21 September 2016

Re: Carport Foundation at 604 Crystal Springs Drive

Robinson Carport  
604 Crystal Springs Drive  
Sanford, NC

**Top View with Dimensions
- Version # 2**

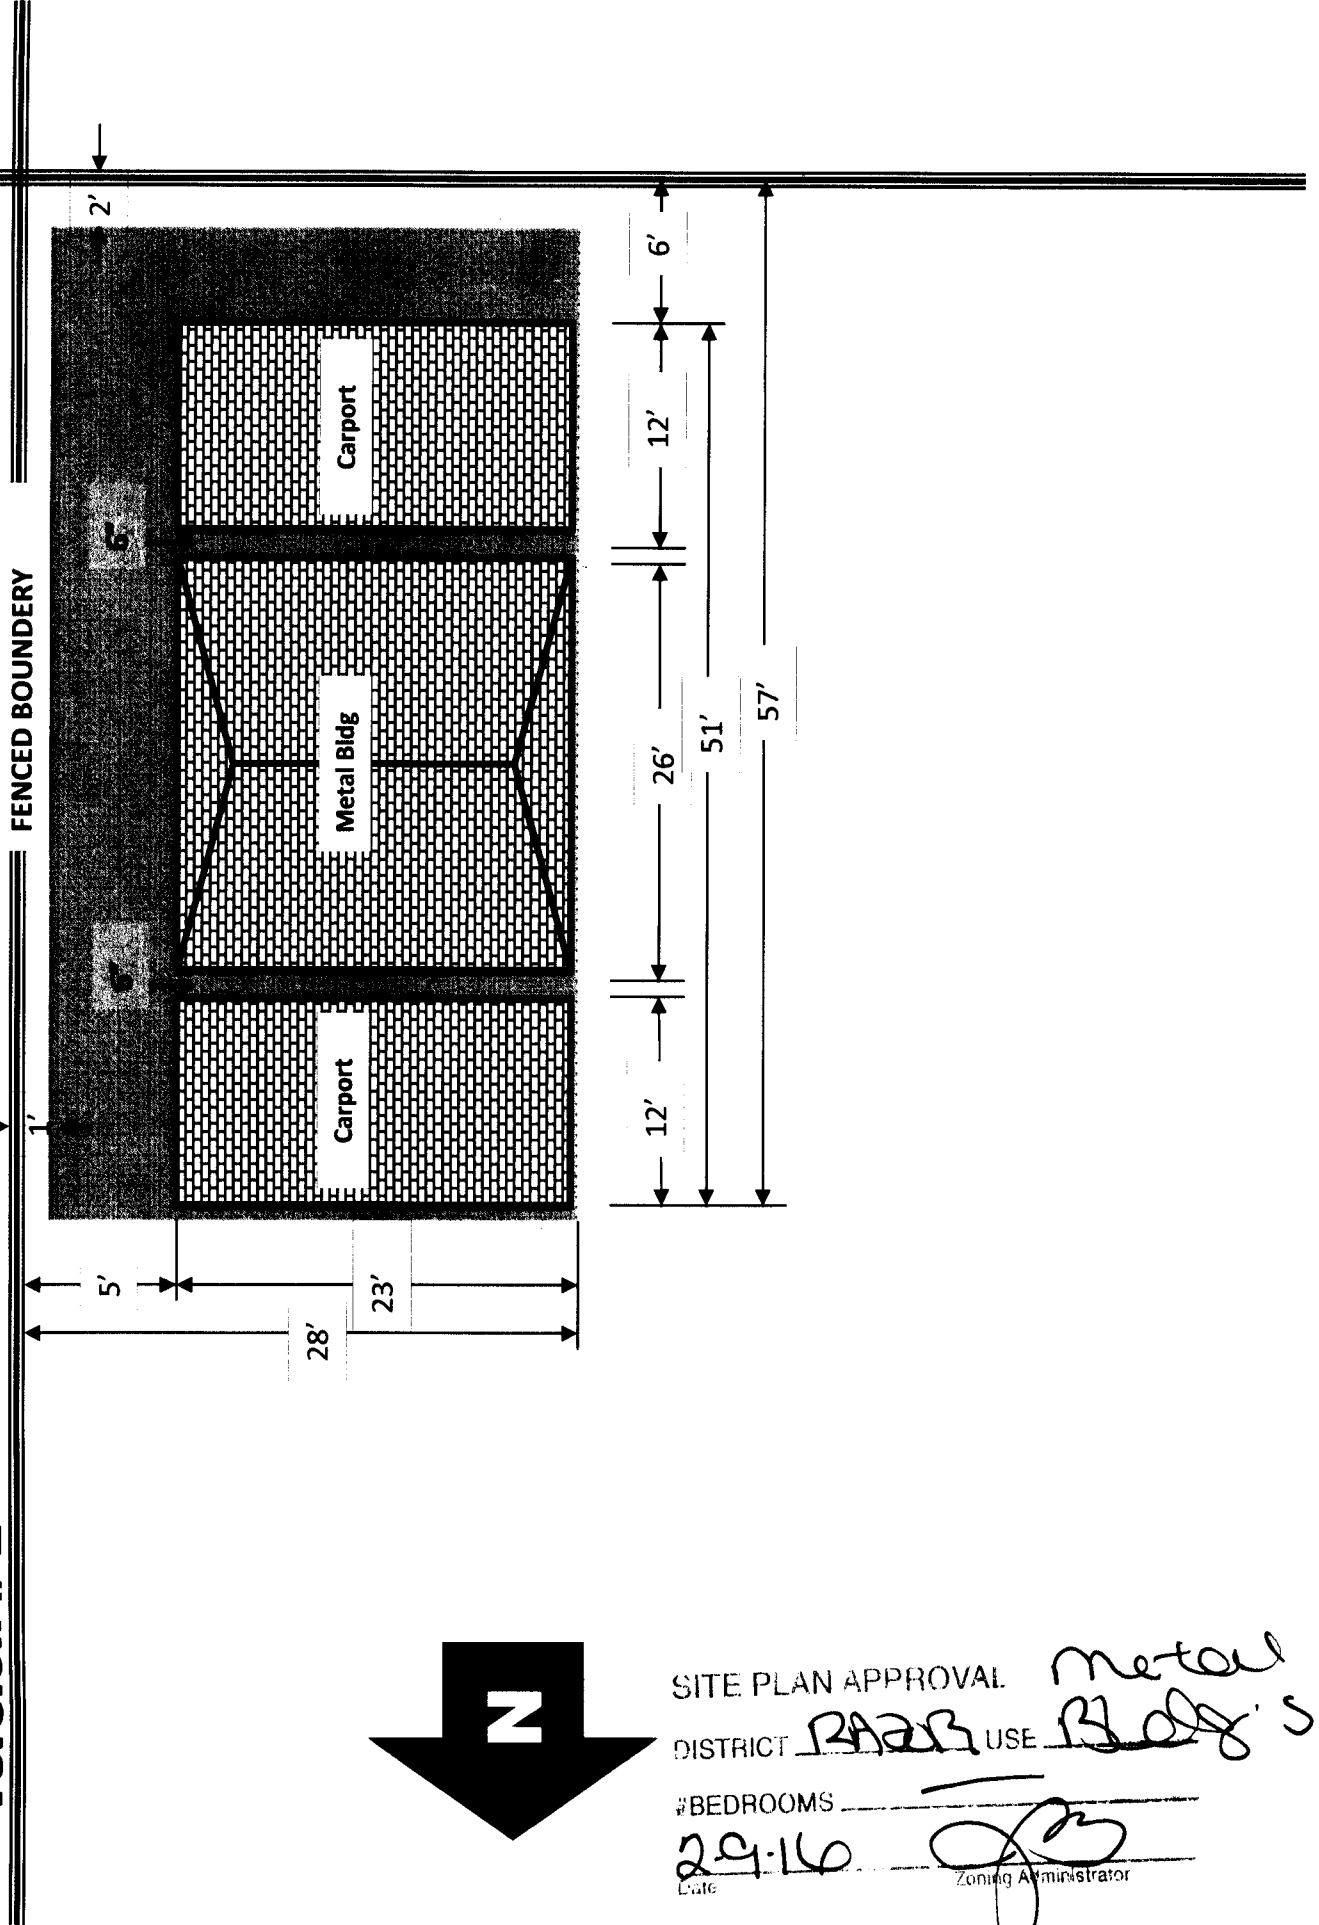
The property in question is a single family residence. "A Plus" Carports constructed a metal building with no foundation, and this will not meet county codes.

JCE recommends removing all equipment, folding back the plastic and rubber mat flooring, and digging the footings under the building where it sits. Each footing will need to have a 36" auger embedded in it and attached to the bottom member of the metal structure

*Exhibit C: The above plan is the design of least impact to the carport. It includes thirteen (13) total concrete footings with augers, as well as the addition of eleven (11) 36" augers (only), placed accordingly.*
